**WELWYN HATFIELD BOROUGH COUNCIL
EXECUTIVE DIRECTOR - PLANNING, PUBLIC PROTECTION AND GOVERNANCE**

DELEGATED APPLICATION

Application No: 6/2017/2667/FULL
Location: 58 Plough Hill Cuffley Potters Bar EN6 4DS
Proposal: Erection of a detached 4-bedroom house following demolition of existing
Officer: Mr David Elmore

Recommendation: Refused

Rev	Detail	Date
A	Elevation, windows and internal layout	Nov 2017
Location		
58 Plough Hill		
Cuffley EN6 4DS		
Scale	Date	
As shown	Nov 2017	
Drq no		
DB / C / 205

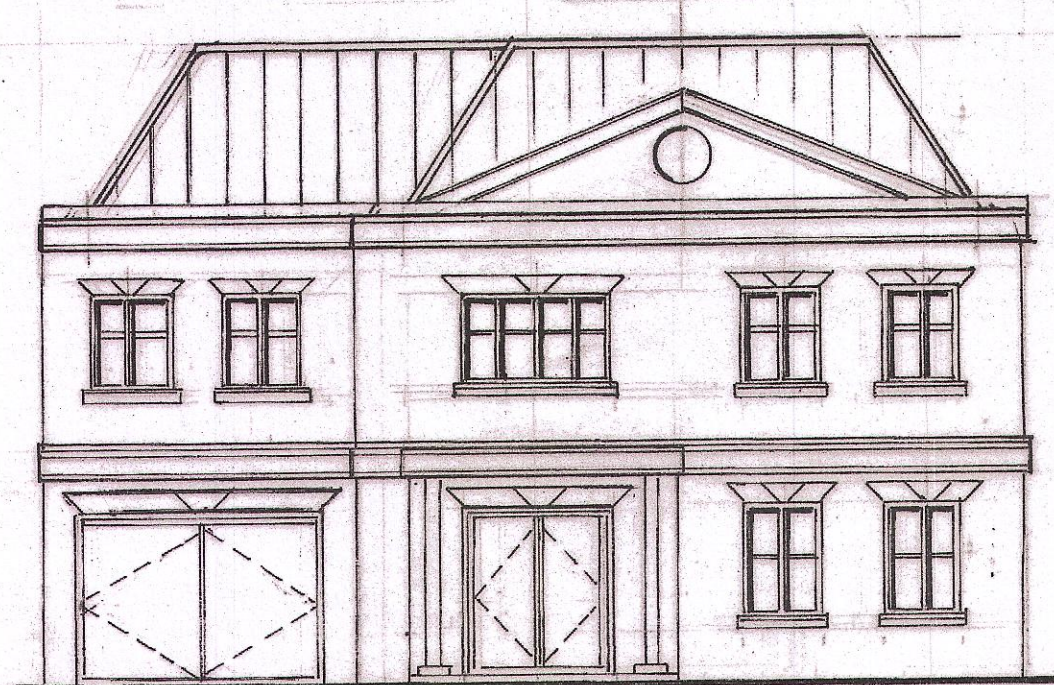
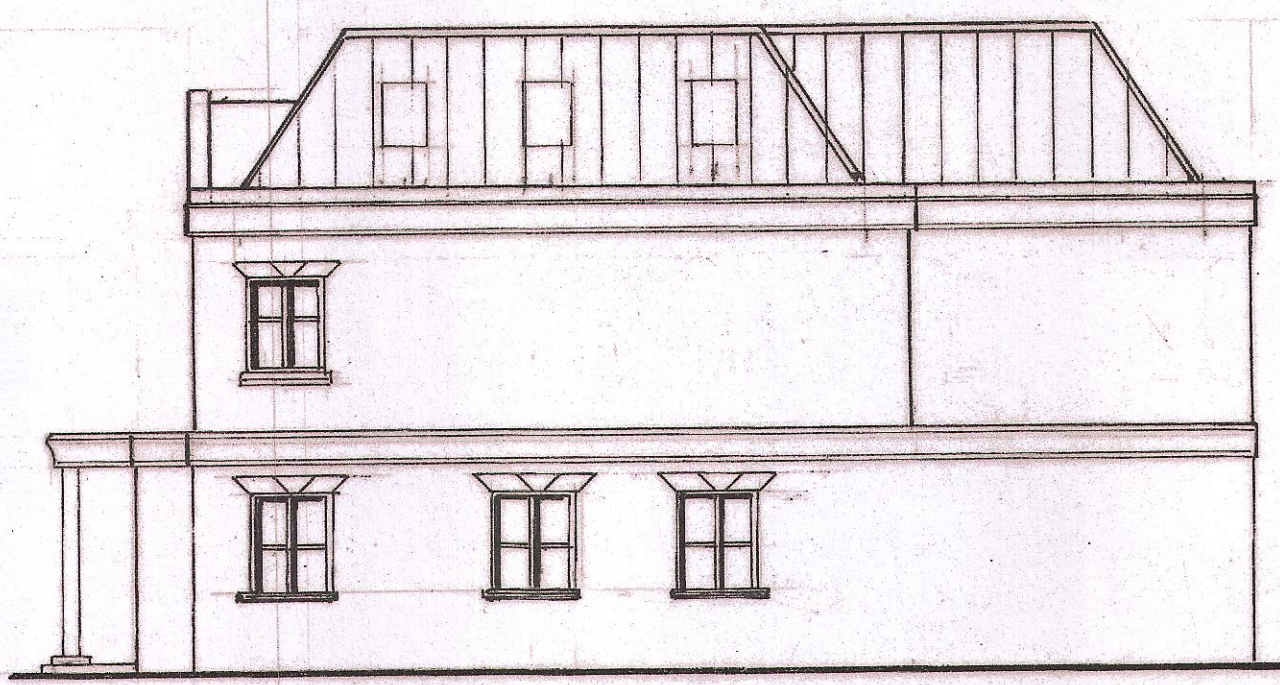
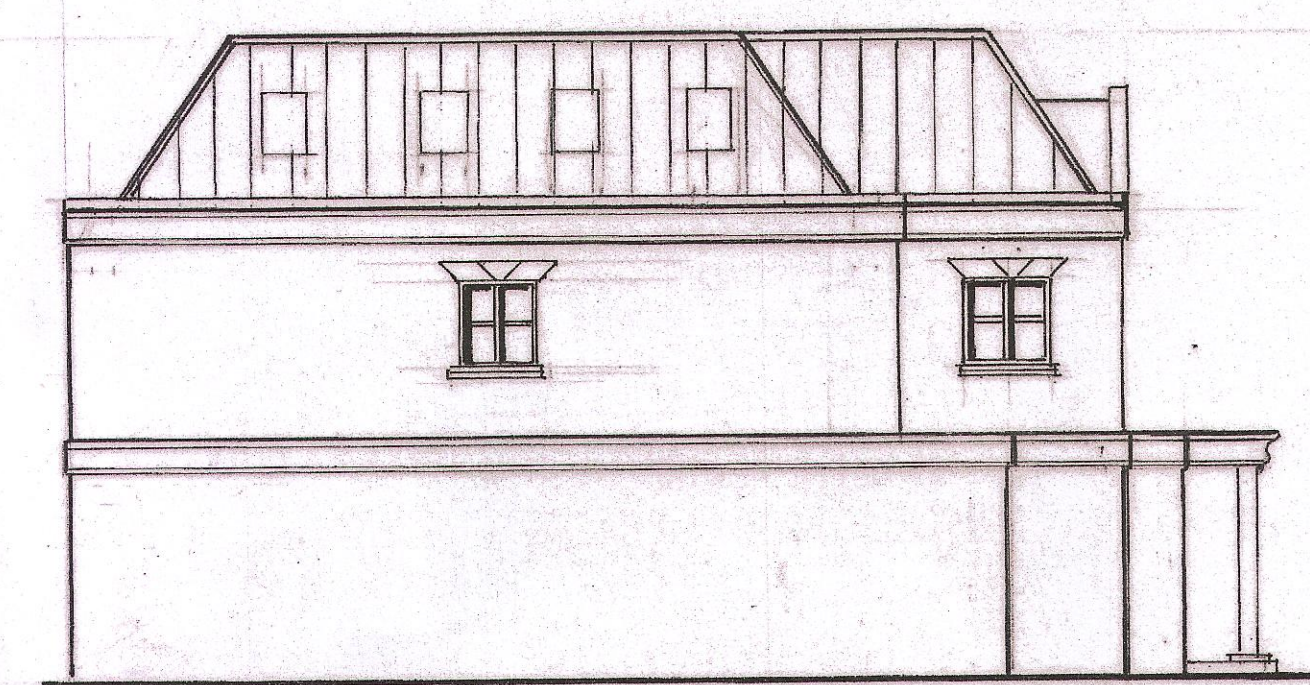
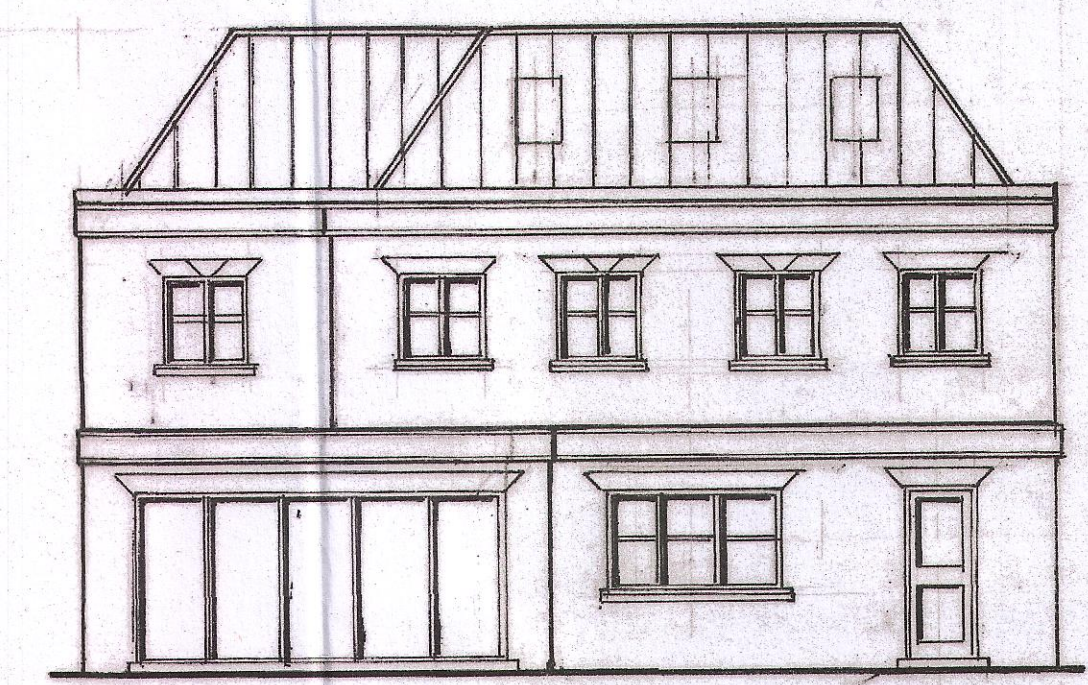
1. The proposed dwelling, by virtue of its design and appearance, would look incongruous in the streetscene, and as a result, fails to respect and relate to the character and context of the area. Consequently, the proposal would be contrary to Policies D1, D2 and GBSP2 of the Welwyn Hatfield District Plan 2005, Supplementary Design Guidance 2005 (Statement of Council Policy) and National Planning Policy Framework 2012.
